From: Joanne Lewis
Sent: 12 August 2020 07:26
To: Matt Bridle
Cc: Maria Tomalova
Subject: RE: BN/81/20/DOC

From: Matt Bridle [REDACTED]
Sent: 06 August 2020 14:22
To: Joanne Lewis <Joanne.Lewis@arun.gov.uk>
Subject: BN/81/20/DOC

title
Proposed Construction Management Plan

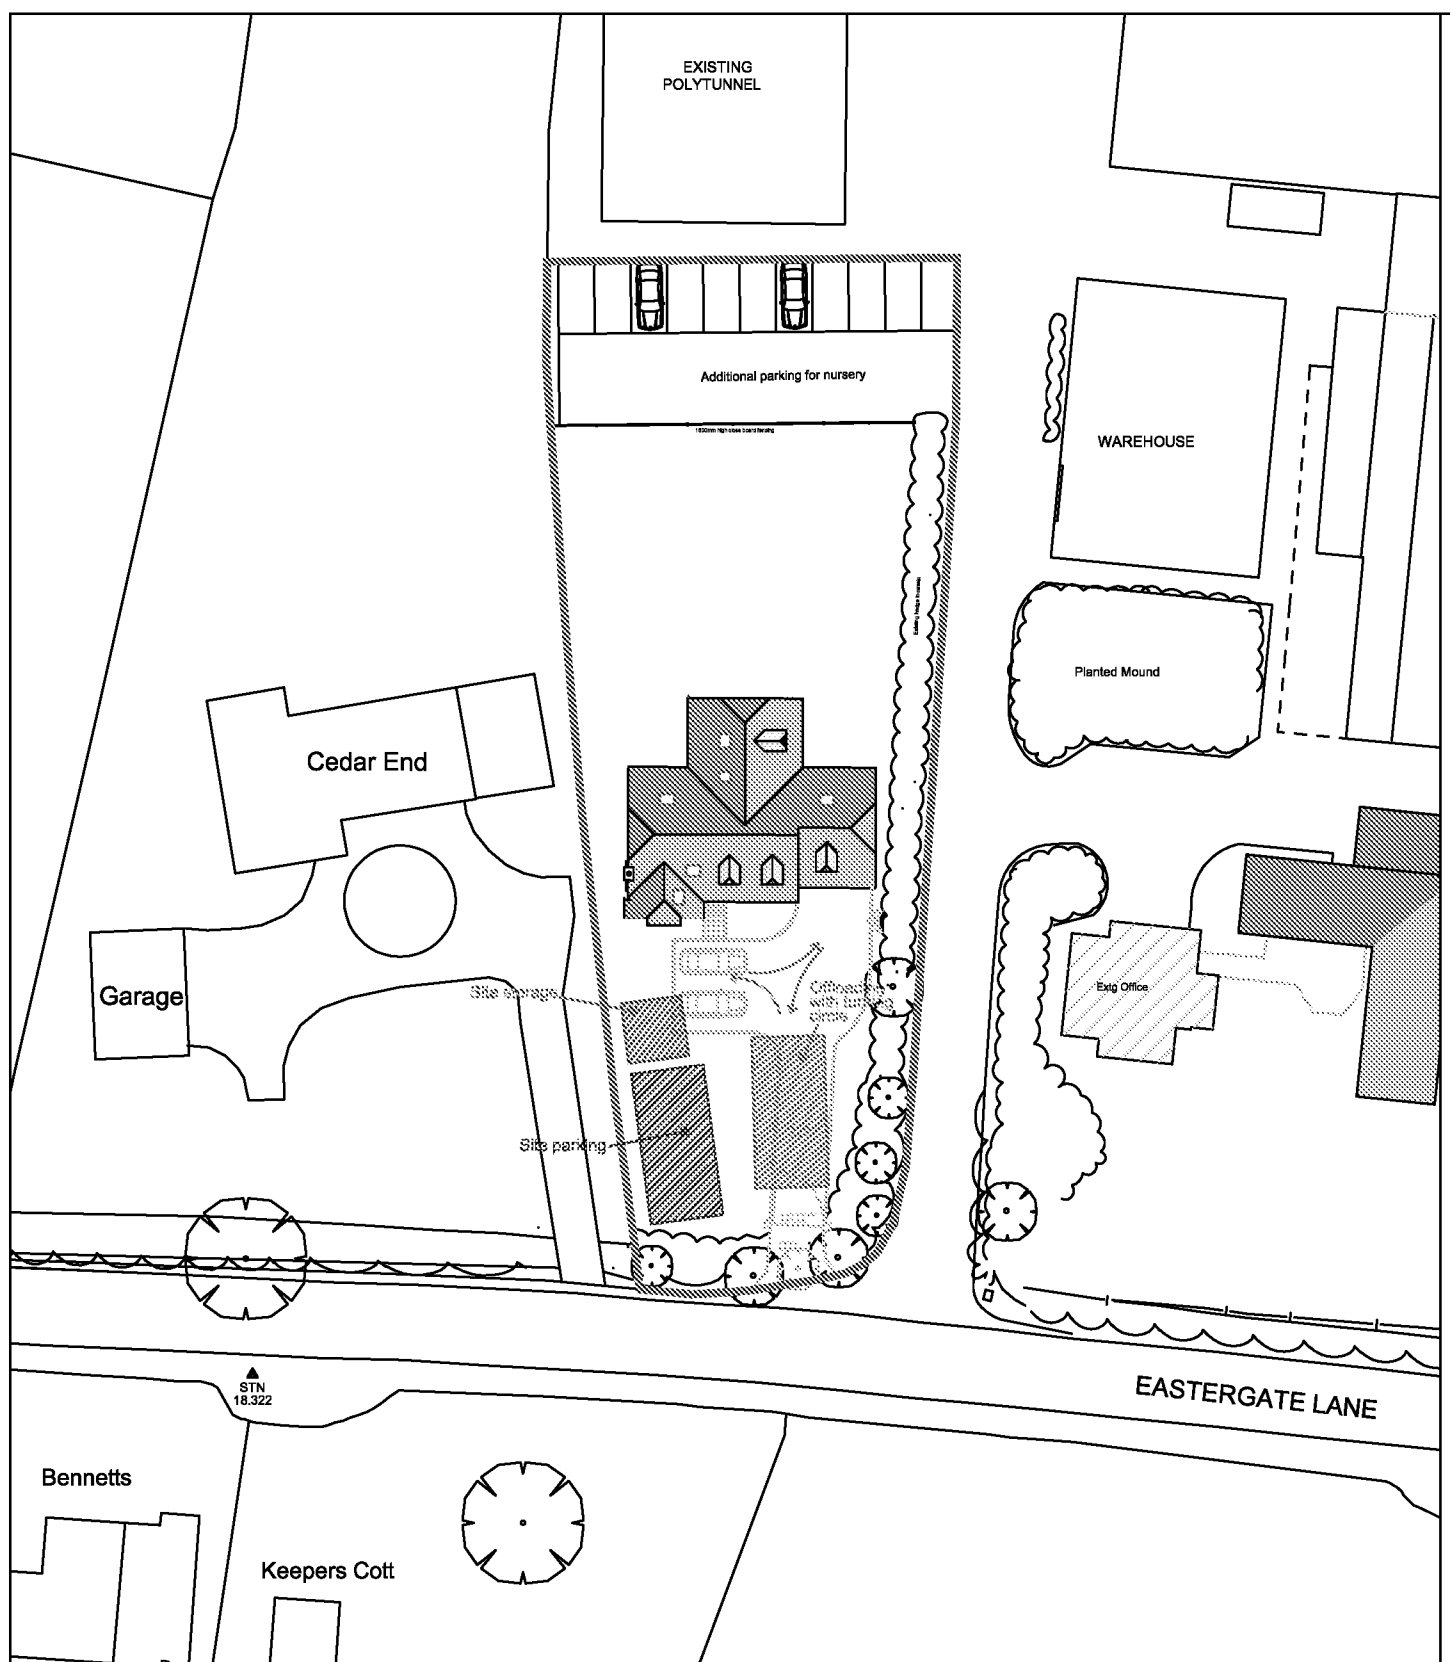
c) I would advise that consideration is given to the control of vocal noise and the use of radios which are common causes of complaint from neighbours on building sites, particularly during the summer when people want to be in the garden and have windows open.

h) Heras fencing is not sufficient to protect the adjacent residents from noise and dust from the site. If there is no other fence/boundary currently in place a more solid hoarding needs to be provided along any site boundary that adjoins residential premises. The site has a 12 foot hedge/ trees to the east side and front elevation and a 10 ft close board fence between the site and the neighbouring property to the East, the only location for the heras fencing is across the entrance when the site is locked up and to the rear.
